Subdivision Comments

To: Jeremiah Cromie, CDS Planner 2
From: Jesse Cox, Environmental Health Supervisor
Kim Shilley, Public Health Technician
Date: 1/18/2023
RE: SP-22-00005 Johnson-Duvall

TO: All Staff
FROM: Public Works Plan Review Team
DATE: January 26, 2023
SUBJECT: SP-22-00005 Johnson-Duvall

JOHNSON-DUVALL SHORT PLAT
 PART OF SECTION 25, T. 18 N., R. 18 E., W.M.
 KITTITAS COUNTY, WASHINGTON

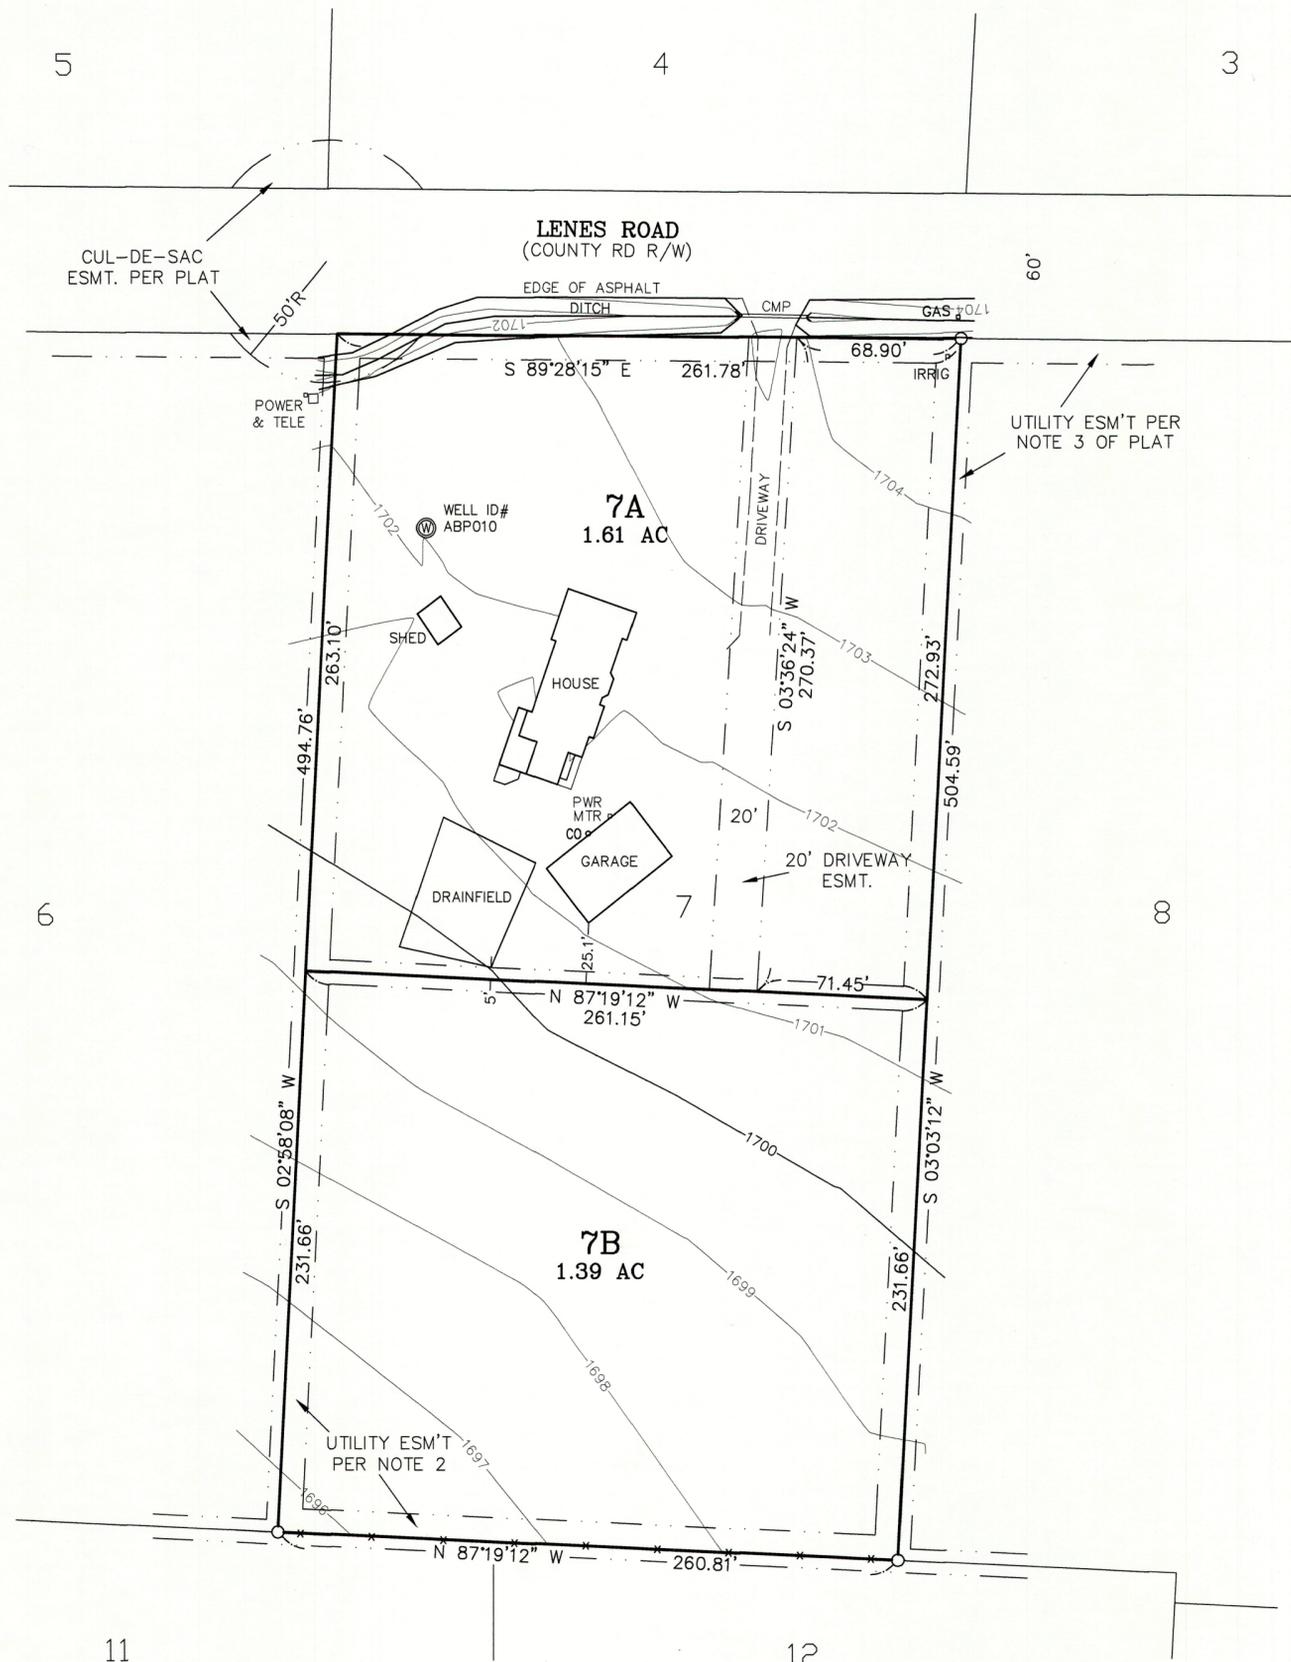
SURVEY	<ol style="list-style-type: none"> 1. Preliminary Short Plat does not meet the requirements of WAC 332-130-145 Topo Elements on Maps. 2. Prior to final approval, property corners will need to be shown on the new division line.
FLOOD	No comments (SC)
WATER MITIGATION/ METERING	<p>For the proposed short plat, the applicant must provide legal water availability for all new uses on the proposed lots of this project, which can be provided through mitigation certificates. Prior to final plat approval and recording, the following conditions shall be met:</p> <p>In accordance with KCC Chapter 13.35.027, the applicant shall provide one of the following documents before final plat approval:</p> <ol style="list-style-type: none"> 1. A letter from a water purveyor stating that the purveyor has adequate water rights and will provide the necessary water for the new use; 2. An adequate water right for the proposed new use; or 3. A certificate of water budget neutrality from the Department of Ecology or other adequate interest in water rights from a water bank. <p>All applicants for land divisions shall also submit information on "proximate parcels" held in "common ownership" as those terms are defined in WAC 173-539A-030 and otherwise demonstrate how the proposed new use will not violate RCW 90.44.050 as currently existing or hereafter amended.</p> <p>Failure to obtain mitigation before commencement of an activity requiring mitigation shall be a code violation subject to enforcement under Title 18 KCC.</p> <p>Final Plat Notes</p> <p>The following notes shall be placed on the face of the plat:</p> <p>C-1 “Metering is required for all new uses of domestic water for residential well connections and usage must be recorded in a manner consistent with Kittitas County Code Chapter 13.35.027 and Ecology regulations.”</p> <p>C-2 “The approval of this division of land provides no guarantee that use of water under the ground water exemption (RCW 90.44.050) for this plat or any portion thereof will not be subject to curtailment by the Department of Ecology or a court of law.”</p>

Proposed short plat indicates a shared well will be used. If the intention is to utilize a shared well, a signed, notarized, and filed shared well users agreement will also need to be provided before the short plat is completed. If shared wells are to be utilized, the wells must be drilled a minimum of 50 feet from any proposed property line and a signed, notarized and recorded shared waters users' agreement for each shared well must be submitted to our office prior to final plat approval. The applicant must prove physical availability of water for all new uses of water proposed lots of this project, which can be provided through a well log or 4 hour draw

A signed and recorded shared water user's agreement between proposed lots is needed. Along with a current water right for the proposed lots.
